Application by Highways England for an Order Granting Development Consent for the A38 Derby Junctions Scheme
The Examining Authority's first written questions and requests for information
Issued on Friday 11 October 2019.

The following table sets out the Examining Authority's written questions and requests for information to assist with the assessment of the application.

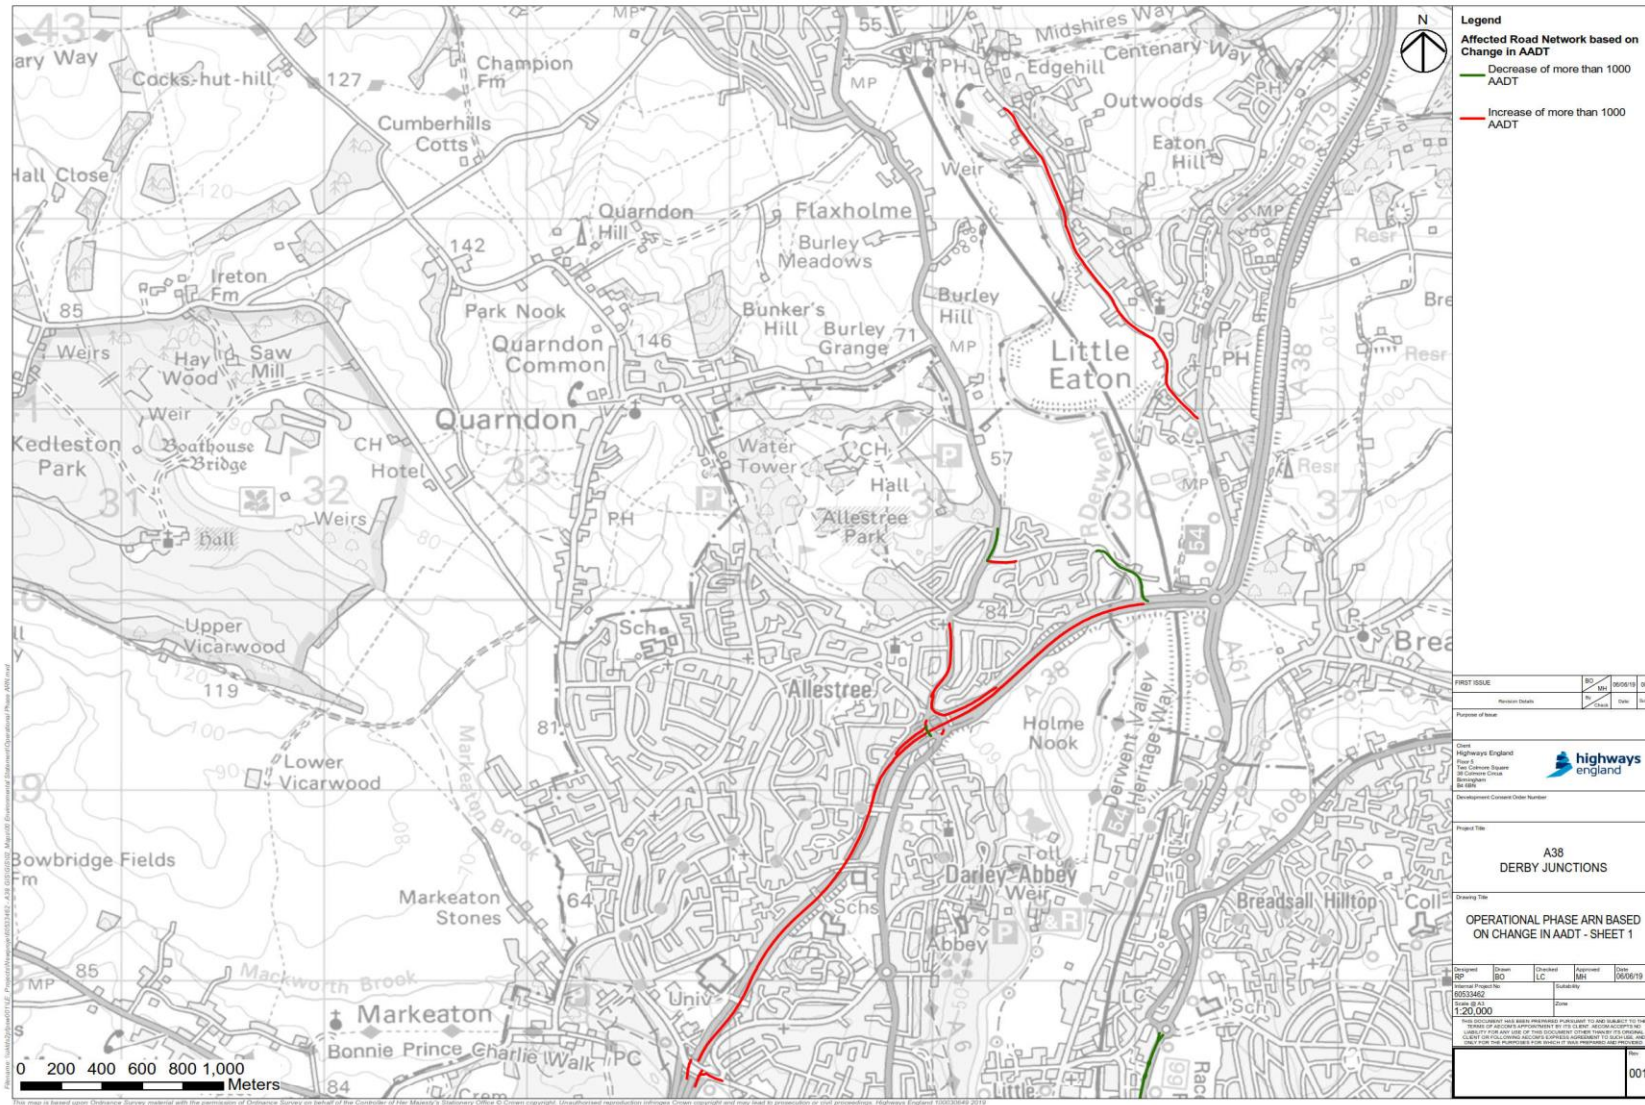
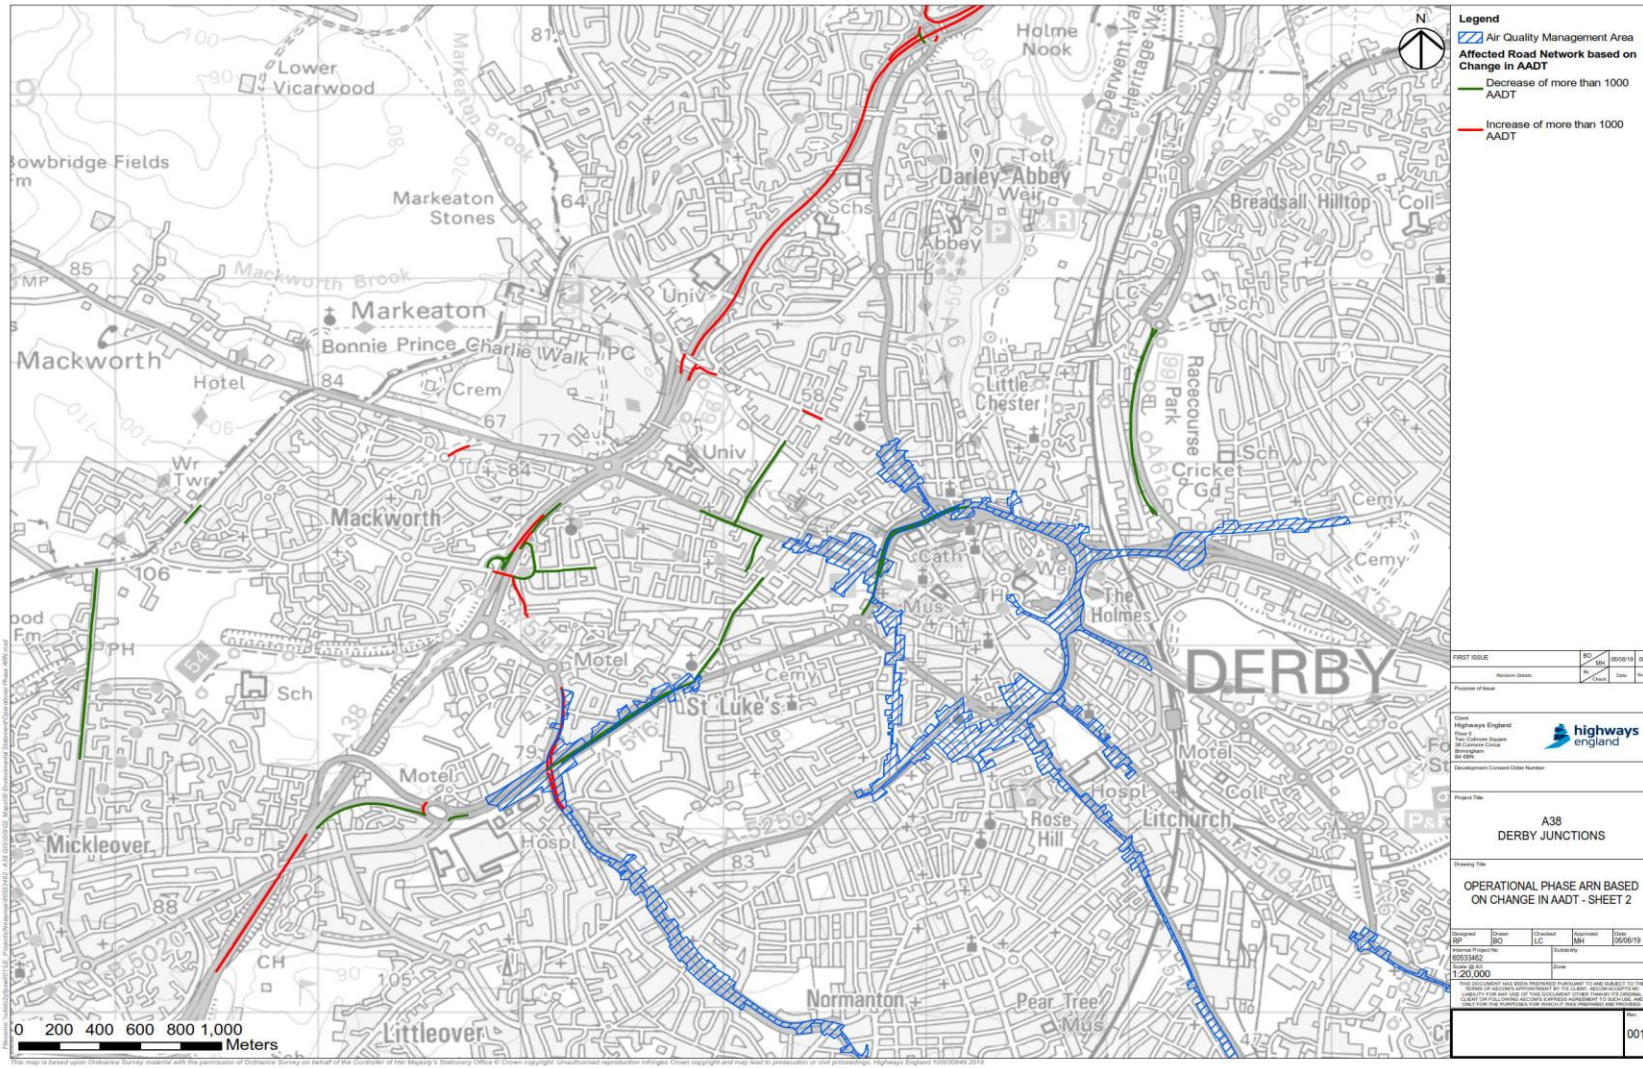
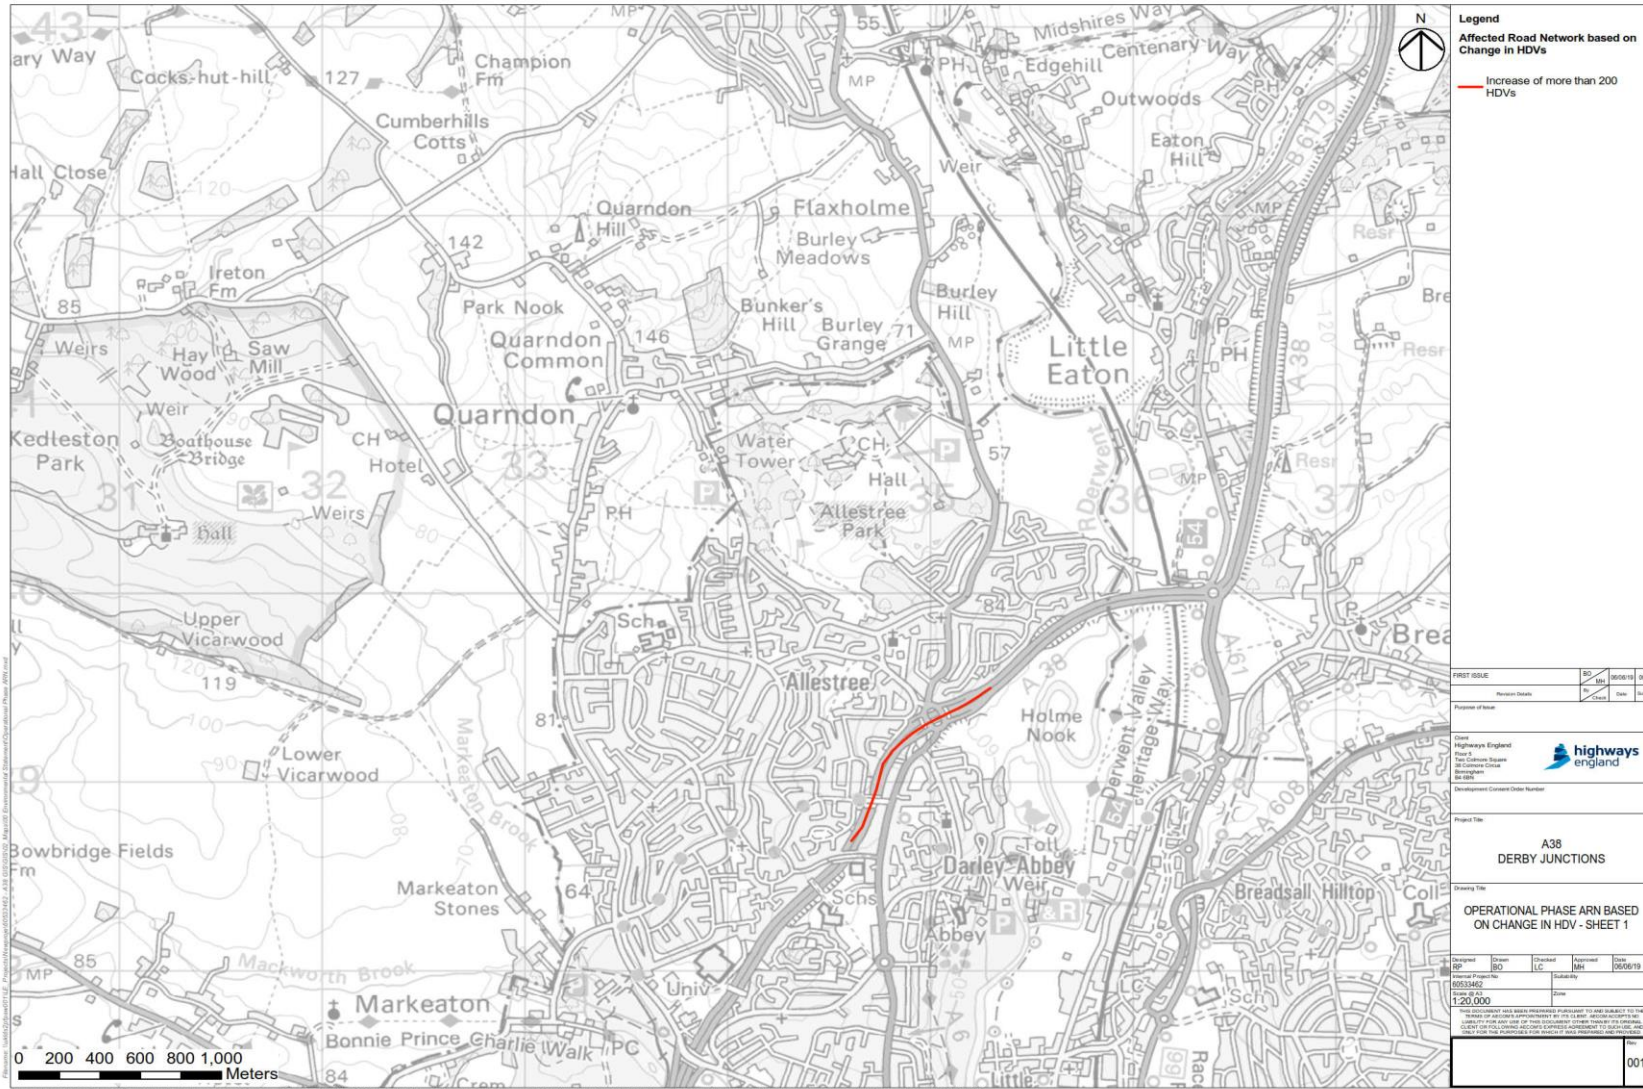
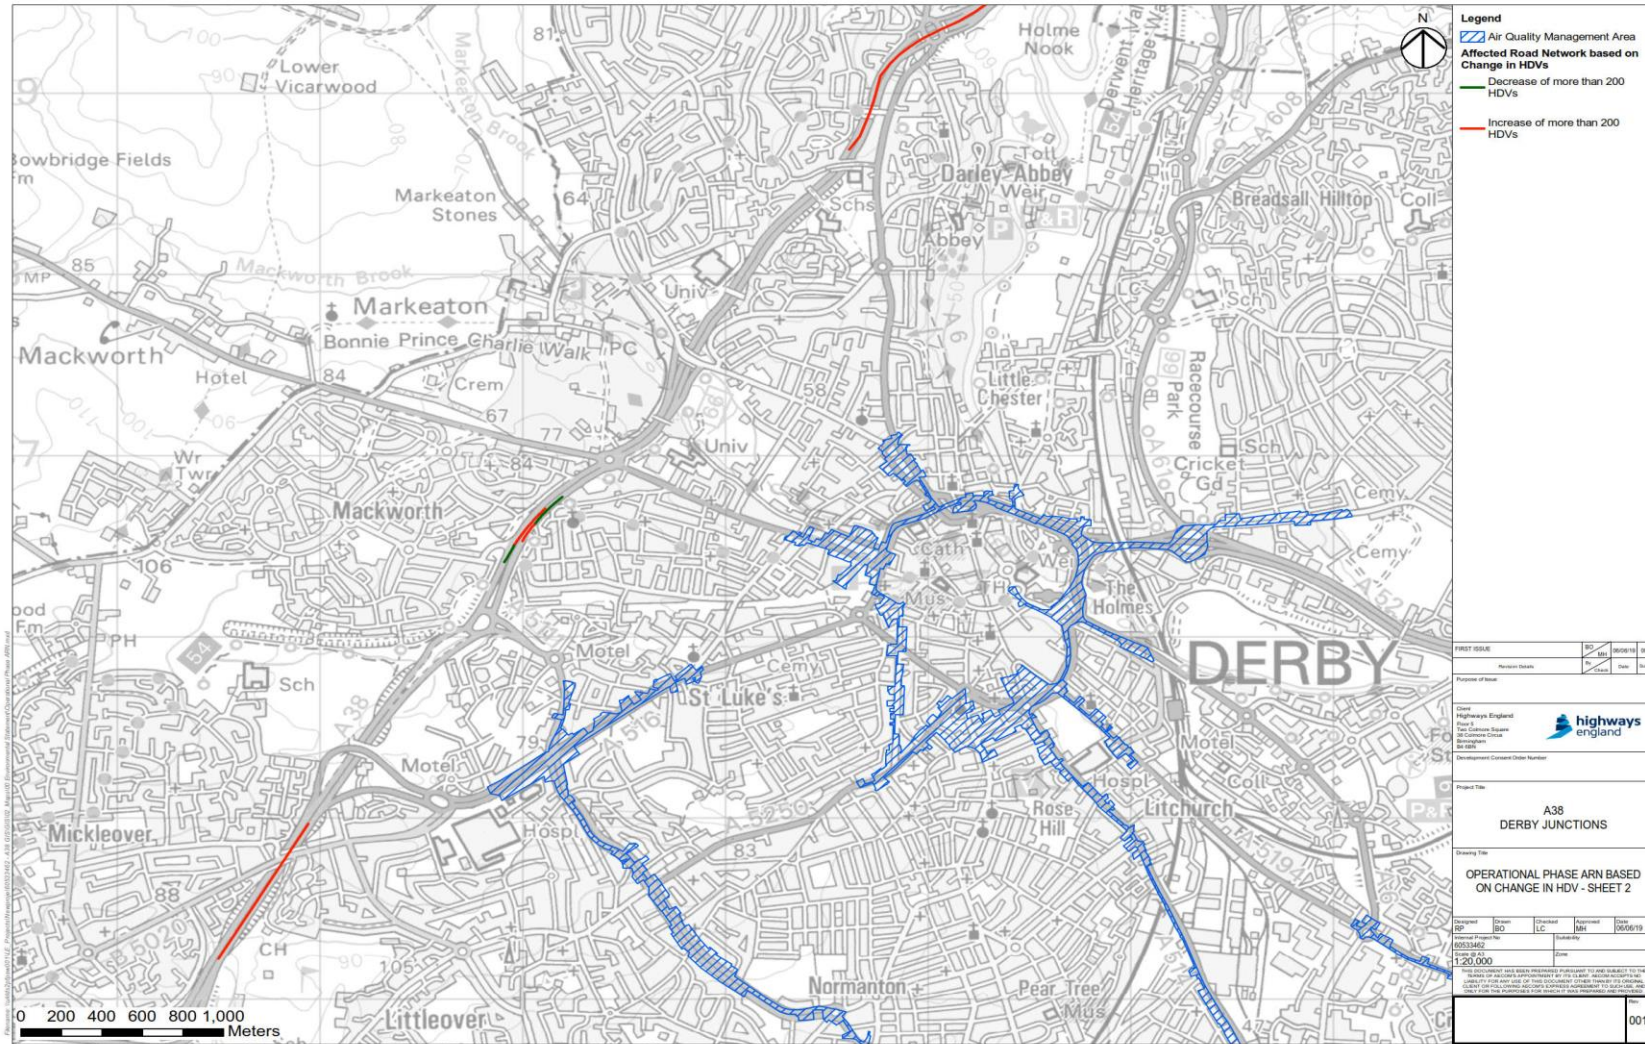
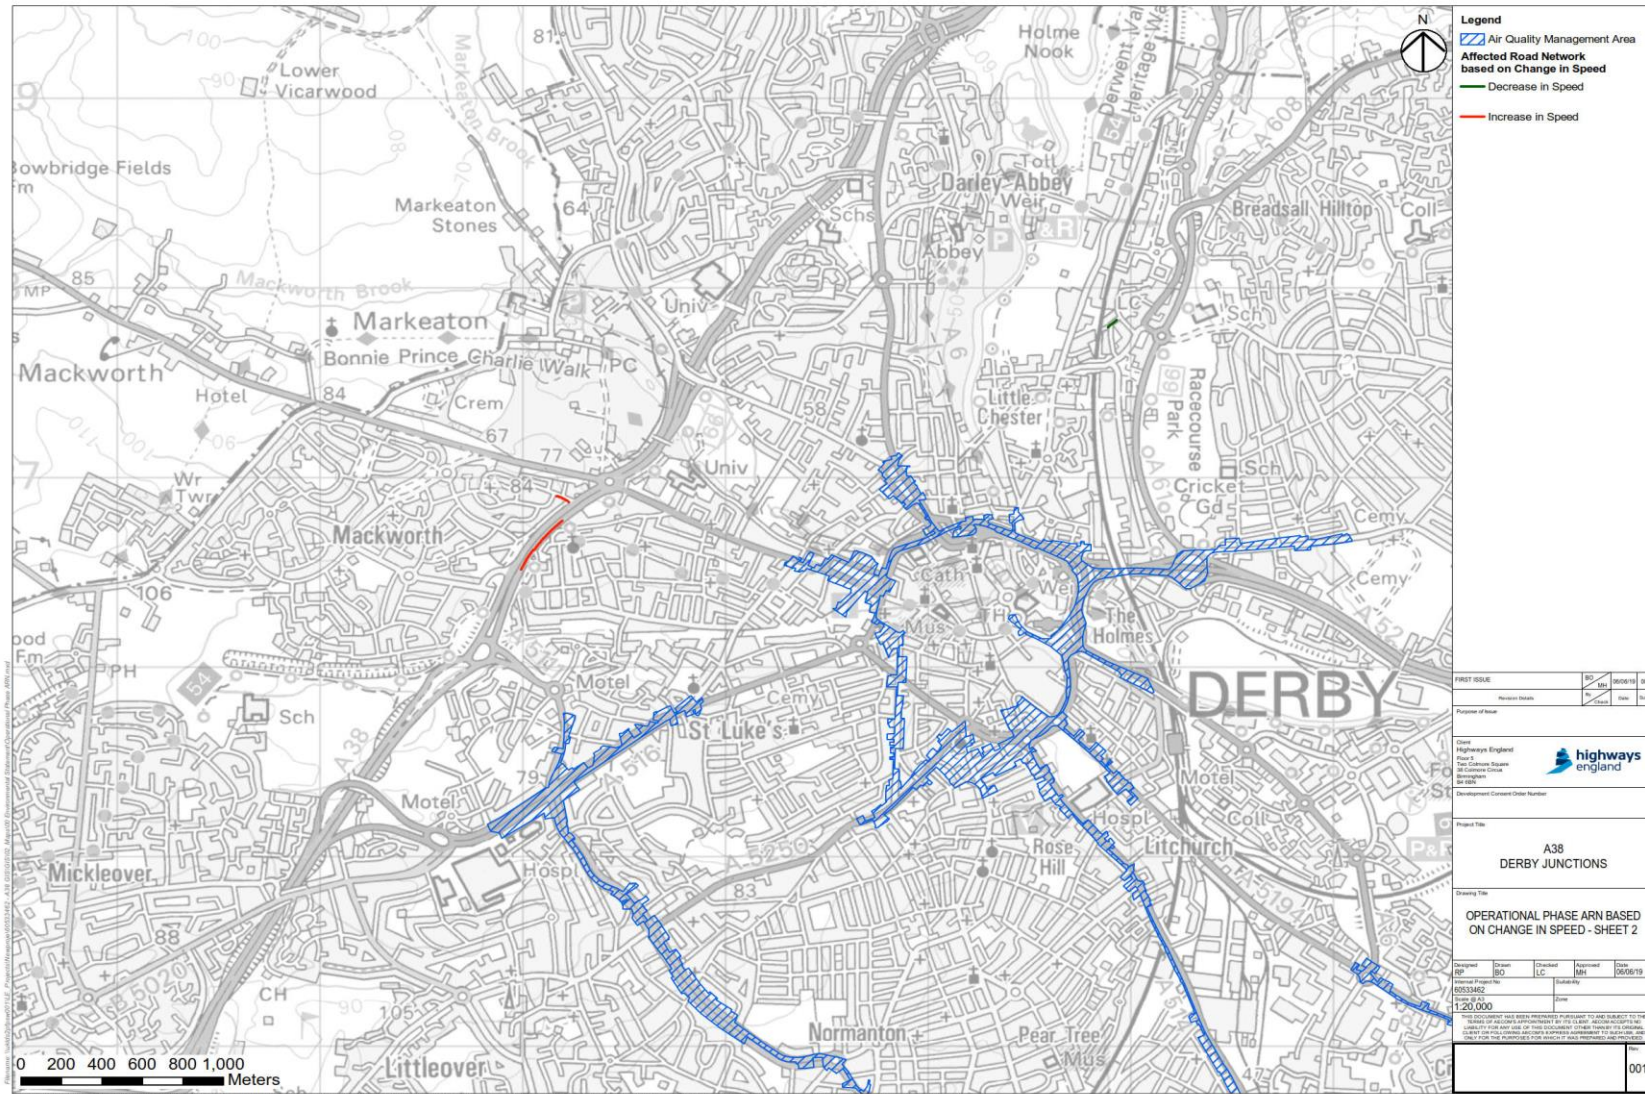
5. Air quality			
Baseline conditions and overall assessment methodology			
5.1.	Applicant	Details of exceedances of air quality screening criteria at affected road links.	The Applicant was issued with s51 advice on 22 May 2019 requesting further information regarding the screening process for inclusion of receptors/road links on the affected road network for further consideration in the assessment. In its response [AS-013] the

No	Question to	Reference	Question
			<p>Applicant provided updated figures [AS-006] to illustrate affected road links. However, detailed information demonstrating how the air quality screening criteria are exceeded were not supplied.</p> <p>Please provide specific details of how the affected road links exceed the DMRB screening criteria during both construction and operation or signpost to where this may be found in the application documents.</p>
